Lancashire Archaeological
Advisory Service

Your ref: 3/2017/0737 and 0762

Planning Applications 3/2017/0737 and 0762: New external doors to drawing room, utilising existing openings to allow garden access. Roof glazing to the atrium roof lantern. New atrium fireplace and chimney stack, re-using existing chimney. New inner hall to replace redundant larder. Re-arrangement of master bedroom door openings. A new terrace accessed from proposed kitchen. Alterations to main entrance gates to provide a safer and more suitable entrance; Standen Hall, Worston Road, Clitheroe BB7 1PR

2. Roof glazing to the Atrium Roof lantern

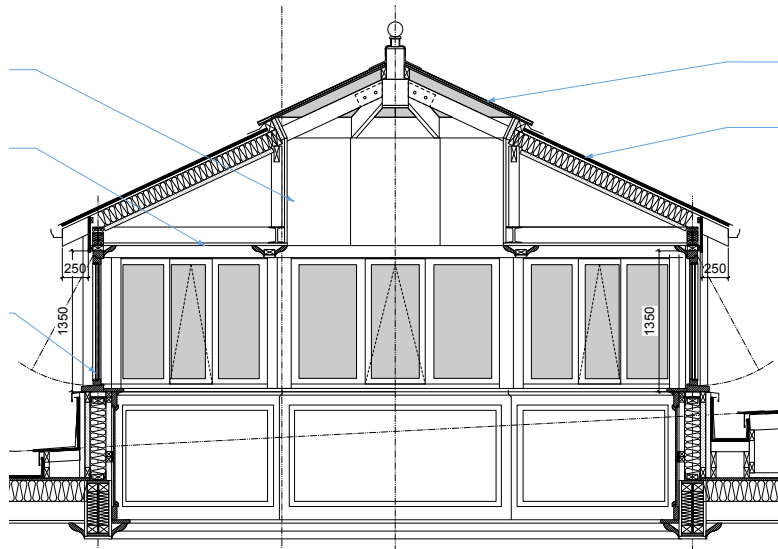
- 1 New external doors to drawing room (G4, GW32 and GW33). This is a relatively minor alteration to one of the later elements of the hall (dated to c.1856) and should not impact the legibility or significance of the room. Recommendation: photograph inside and out prior to alteration.
- 2 Roof glazing to atrium roof lantern. This is a change to the agreed new lantern and has no archaeological significance. Recommendation: no further action required.
- 3 New atrium fireplace and chimney stack, re-using existing chimney. Archaeologically this may be the most significant of the alterations proposed,

3. New Atrium fireplace and chimney stack

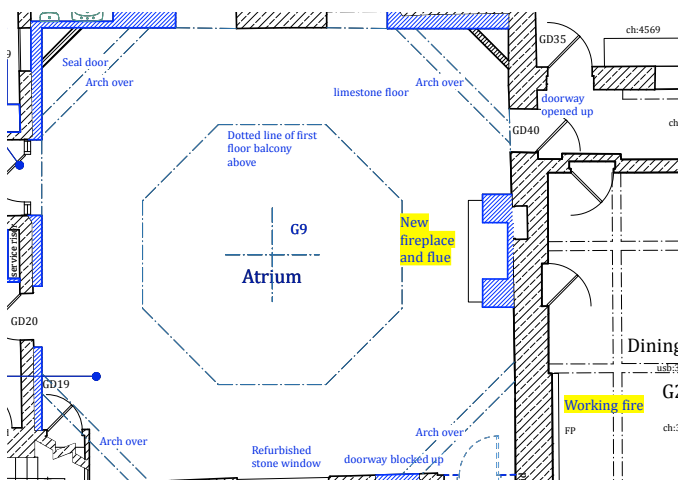
impacting as it does a wall of early 17th century date (Oxford Archaeology North 2017 *Standen Hall, Worston Road, Clitheroe, Lancashire: Historic Building Survey Report* figs 2-4). The fireplace would appear to be located in the space occupied by a blocked doorway, currently in use as a cupboard (GD41 in room G9f *Op. Cit.* pp.19-20; DAS p.3) and could potentially impact the room beyond and what may be another cupboard (G25 and GD59, OA North 2017 Fig 2). We have no objection to the proposed replica chimneypiece and would accept the change to the house overall as a relatively minor alteration to the agreed scheme. What we are concerned about, however, is the potential impact on a substantial portion of one of the oldest surviving walls in the building. In particular we are concerned that there are no details provided concerning the fireplace opening itself, the new chimney stack and how these will be constructed, nor an assessment of the impact on the cupboards GD41 and GD59. The intention to re-use the stonework from the stack removed from room G9c (DAS p.3) is acknowledged and is clearly environmentally sound and minimises the visual impact of the works externally if not the actual physical impact. It is worth noting however that this stonework is of 19th century, not 17th century, origin and that the re-use of these architectural elements could lead to confusion at a later date if the works are not adequately documented now. Recommendations: further details of the proposed fireplace and stack, including a specific impact assessment of the necessary demolition and construction works, need to be provided before a planning decision is reached. It is probable that, should the this element of the proposals be considered acceptable, that archaeological monitoring and recording of interventions into the 17th century wall will be necessary, but a final recommendation will need to wait for the provision of the details requested.

With regard to the proposed new fireplace and chimney, however, further details of the proposals are required which set out in some detail what demolition and construction works are required and how these will impact the significance of the early 17th century walling before an informed decision can be reached. As such we would recommend that this matter is investigated further and more information supplied by the applicants prior to any decision being made.

Extracts of the Existing and Proposed Ground Floor Plans & Photographs of Corridor G17 as existing.

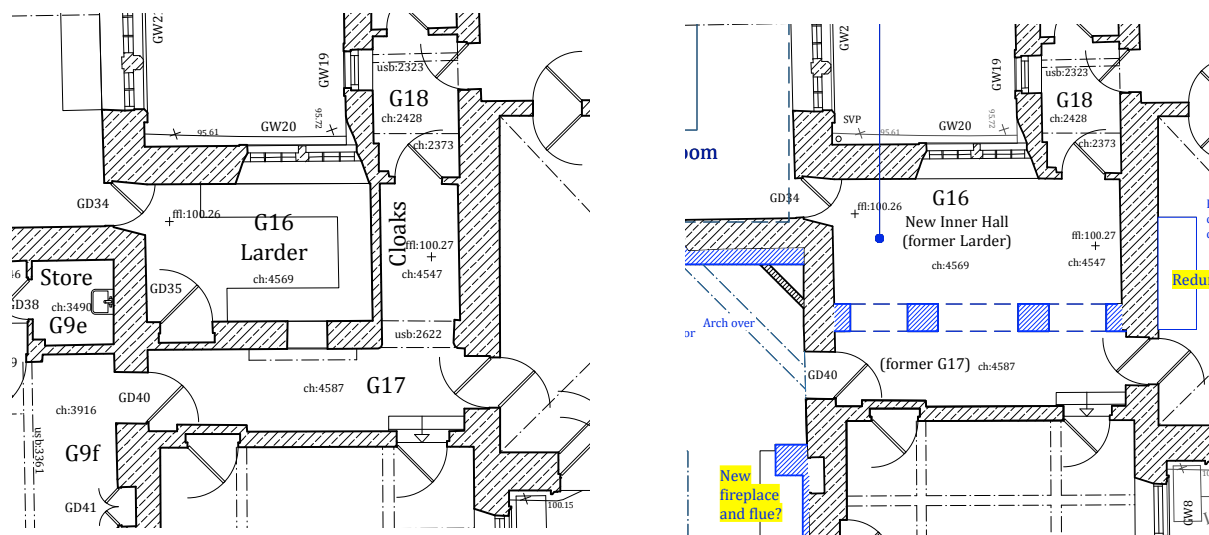
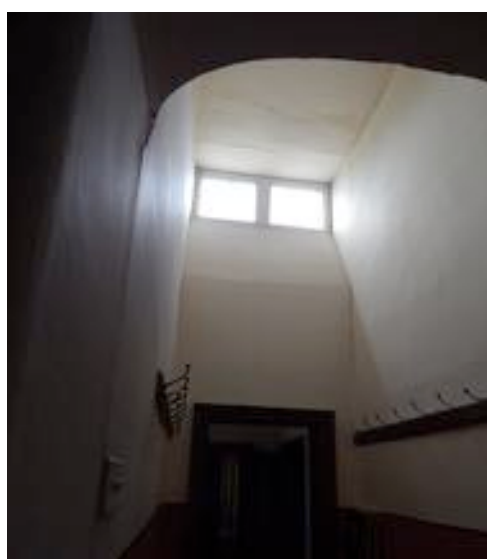
- 4 New Inner Hall to replace redundant larder (G16 and G17, GD35, GW45). Again we would raise no concerns about the work to this earlier 19th century section of the building. Recommendations: photography of both faces of all walls affected, prior to alterations.

5. Master Bedroom arrangement

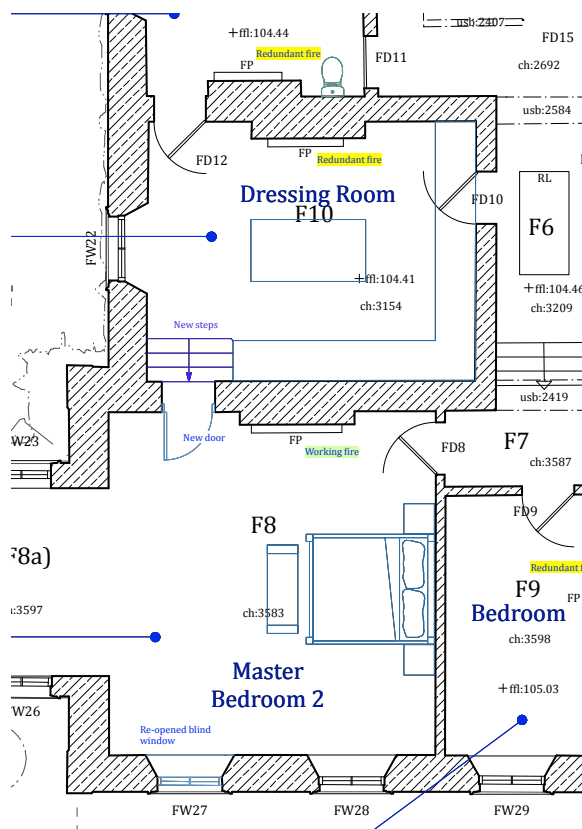
- 5 Re-arrangement of master bedroom door openings (F8, F9, F10, FD9). This intervention is described as requiring "...*less alteration to historic fabric than the approved scheme*" (HIAA p.8). This seems to ignore the fact that the doorway to be retained is in the c. 1856 work, whilst the new opening is through a mid-18th century wall (OAN *Op. Cit.* Fig 3) and makes a significant change to the circulation pattern in this corner of the building. Whilst we would prefer the original proposal, we do not consider that the impact of the proposed change is so severe as to make it unacceptable. Recommendation: return to original scheme if possible. If not then (i) photography of both faces of the wall to be cut through prior to alterations, and (ii) archaeological monitoring during plaster removal and demolition works. If architectural features, blocked openings, evidence of alterations and adaptations, etc. are visible in the wall following plaster removal or encountered during the works then a formal archaeological record should be made of those features, both by further photography and a measured record.
